SHEET: **D1.1**

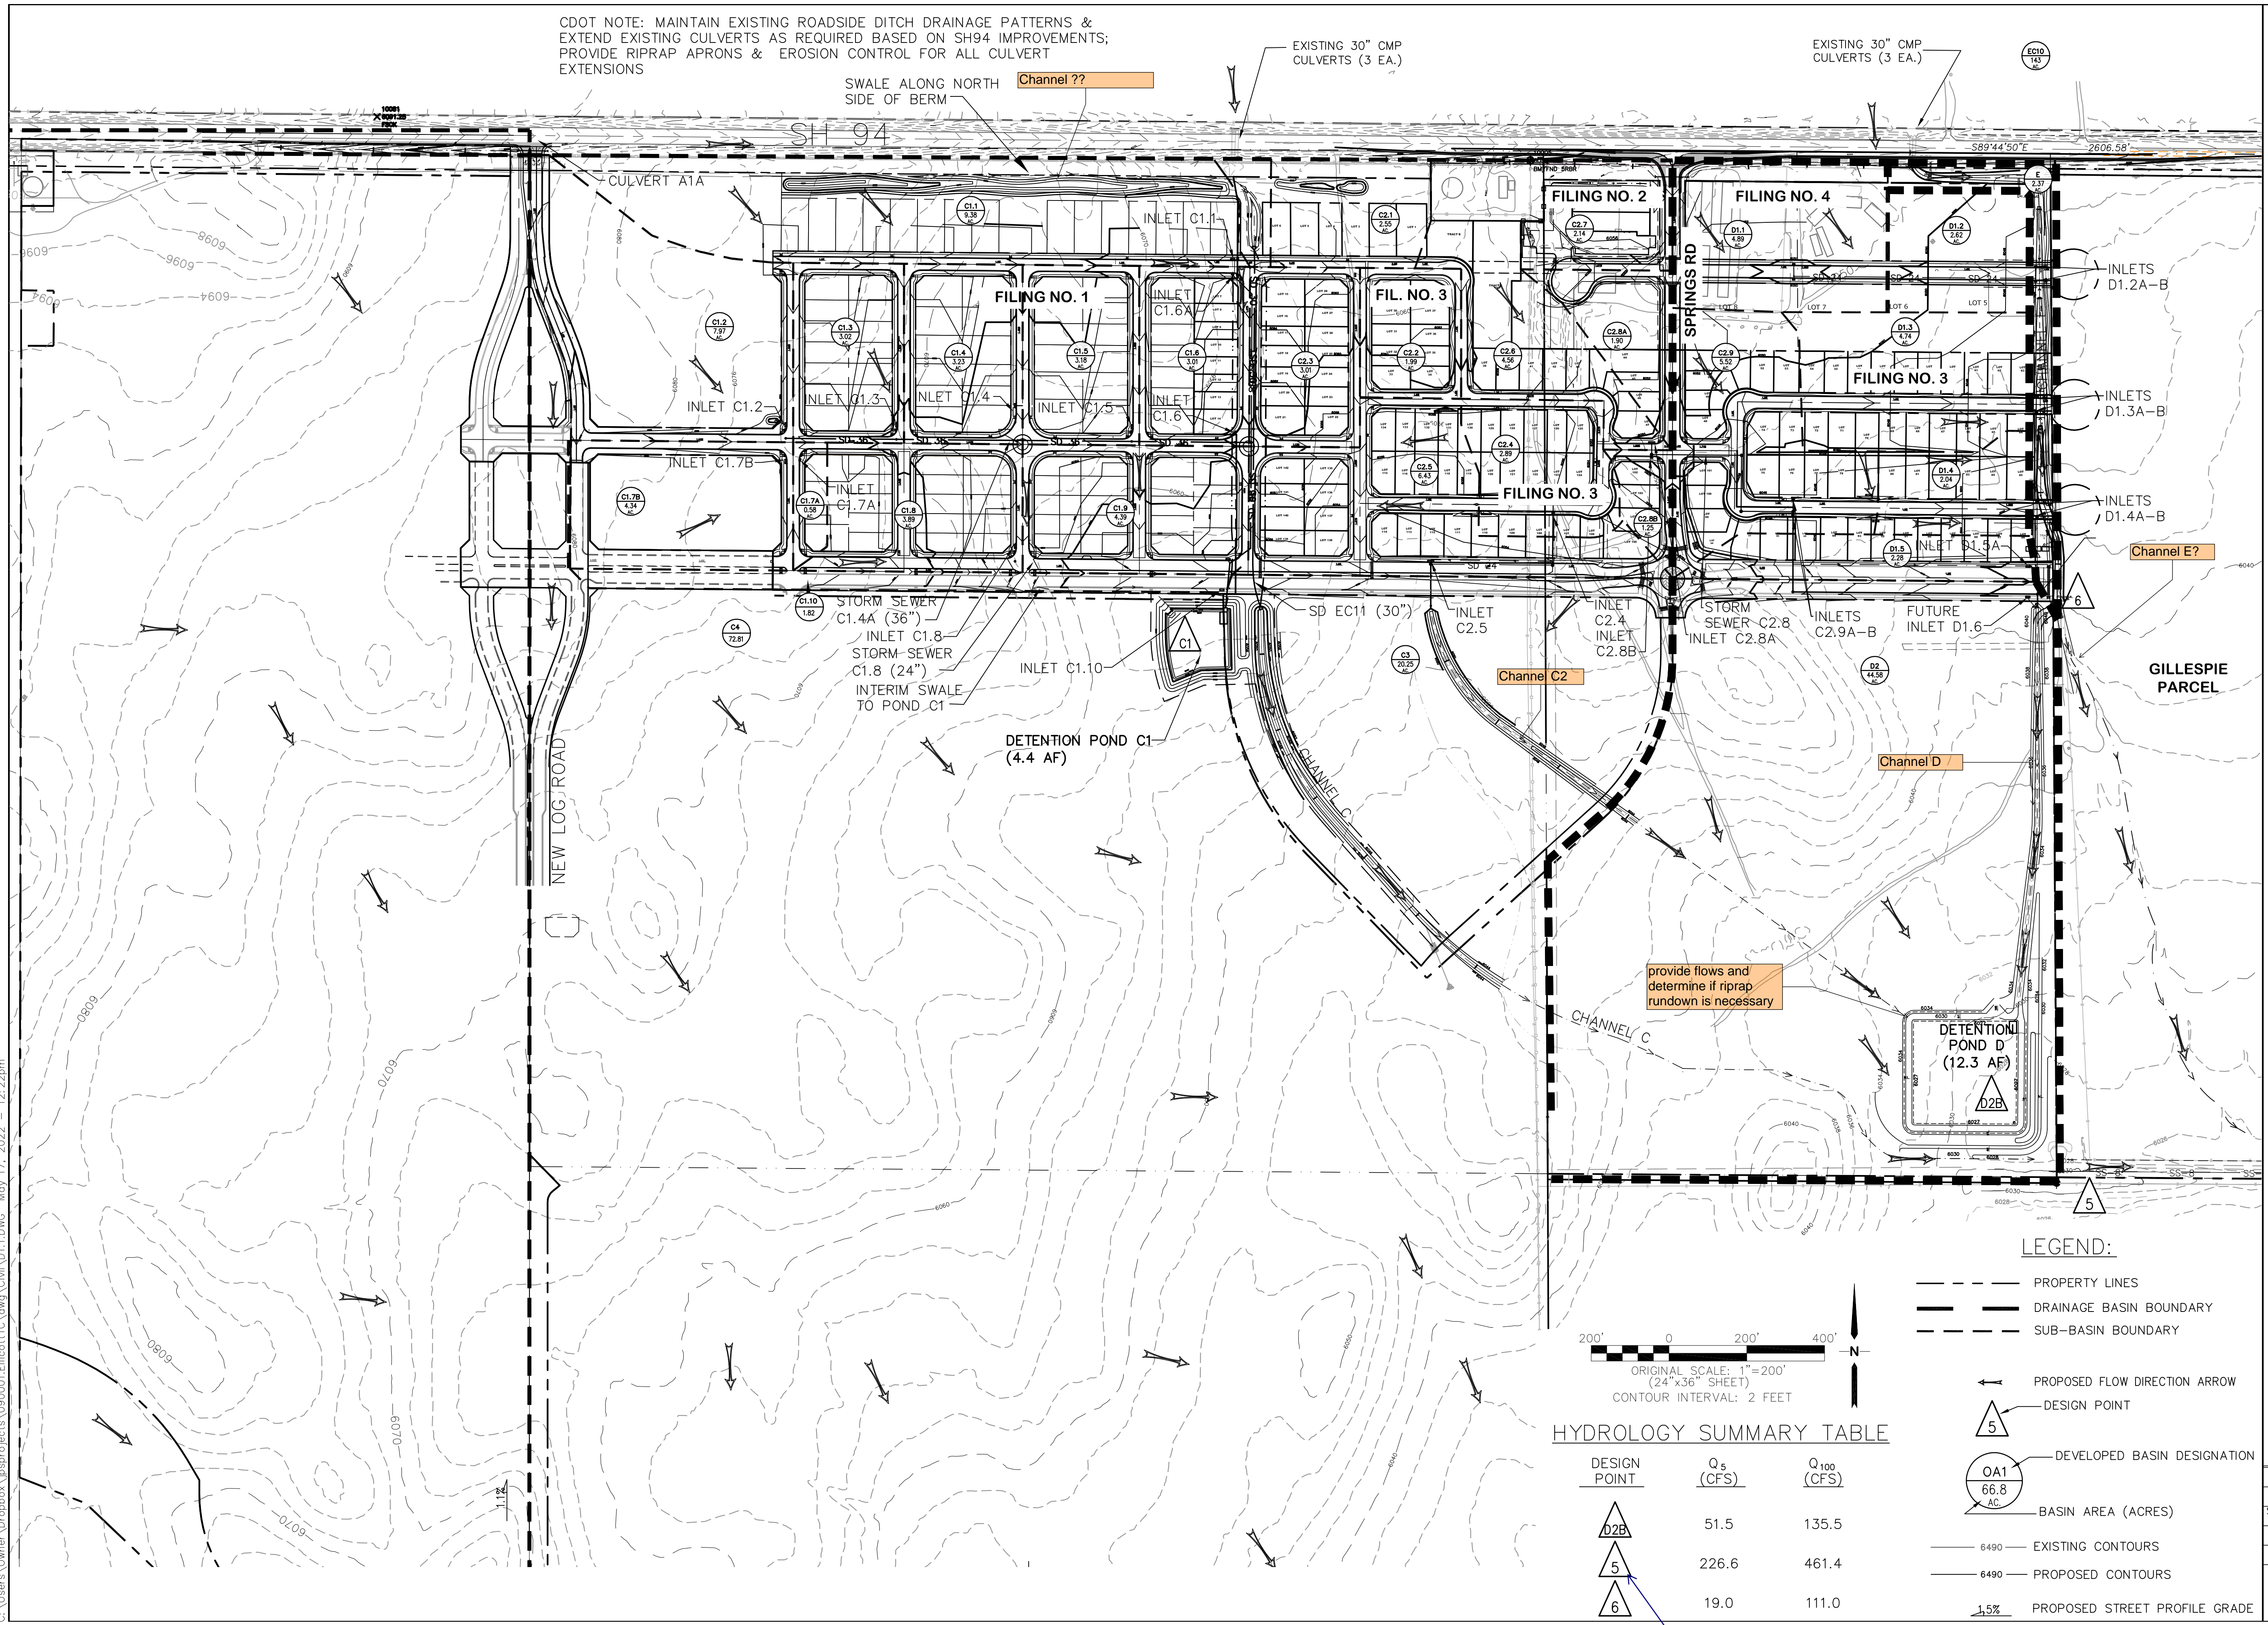
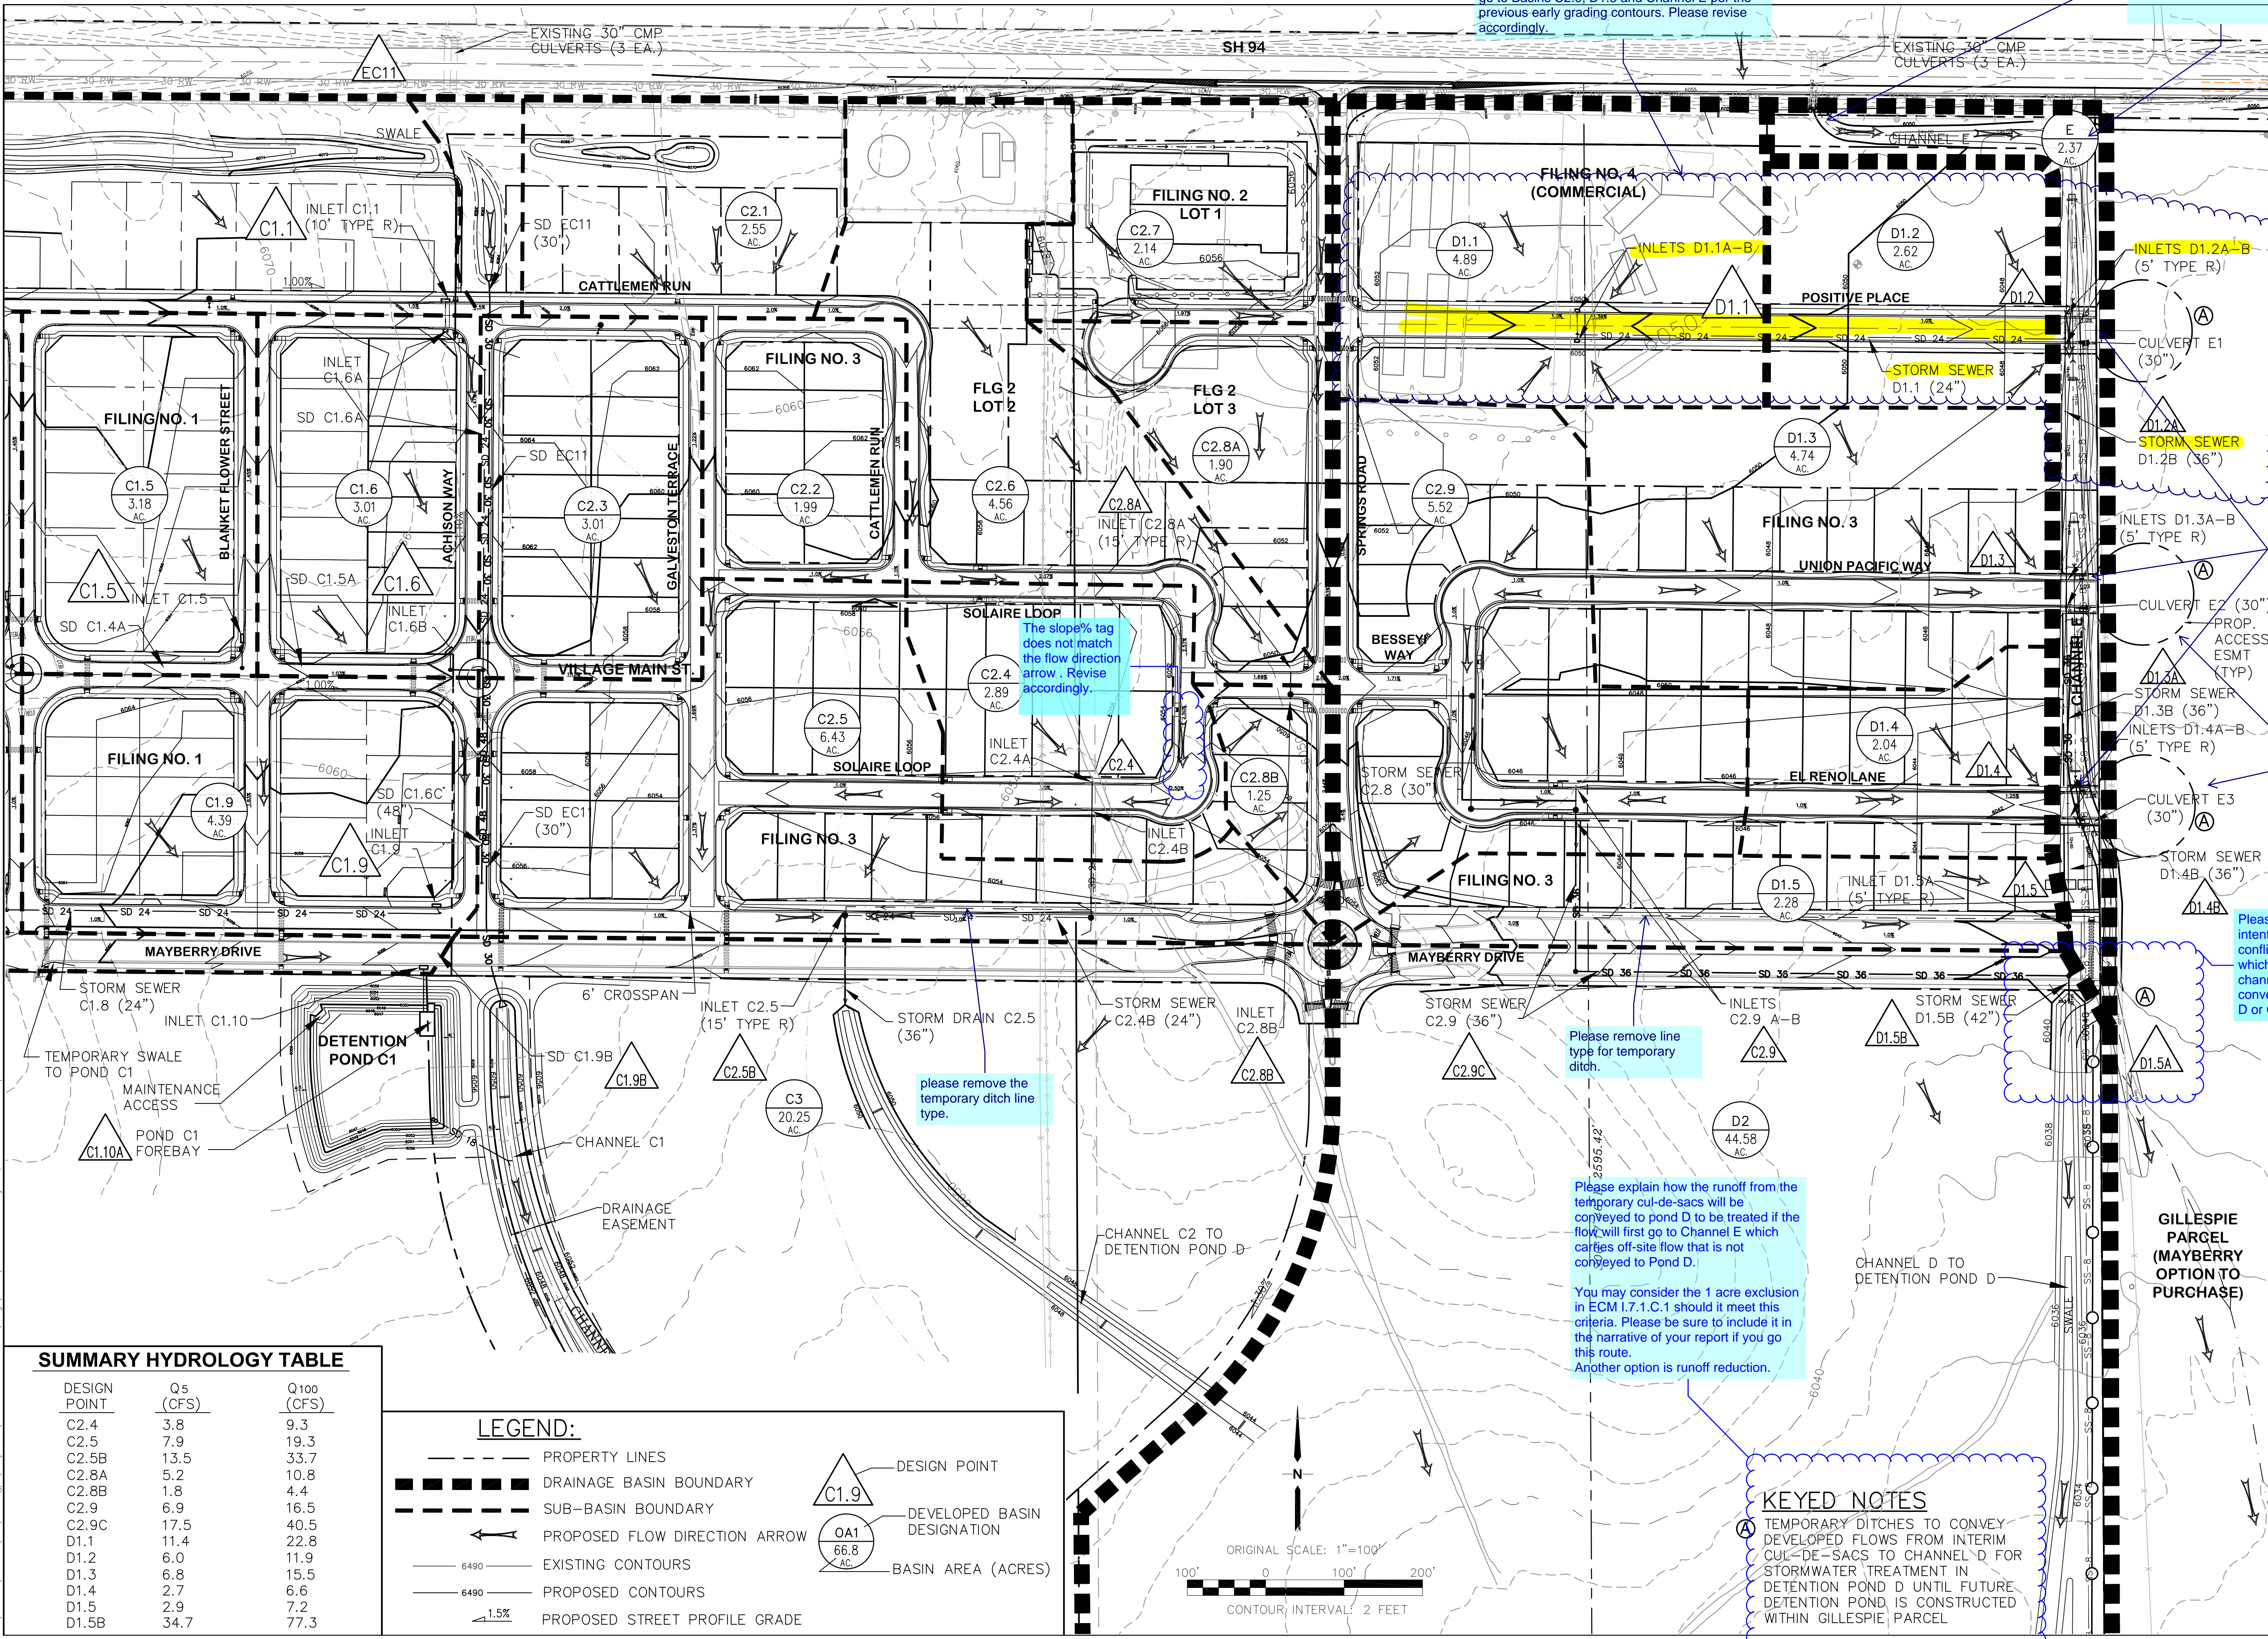
The street grading, inlets storm sewers should not be shown as they do not reflect actual conditions for Filing 3. Flow from these basins will go to Basins C2.9, D1.3 and Channel E per the previous early grading contours. Please revise accordingly.
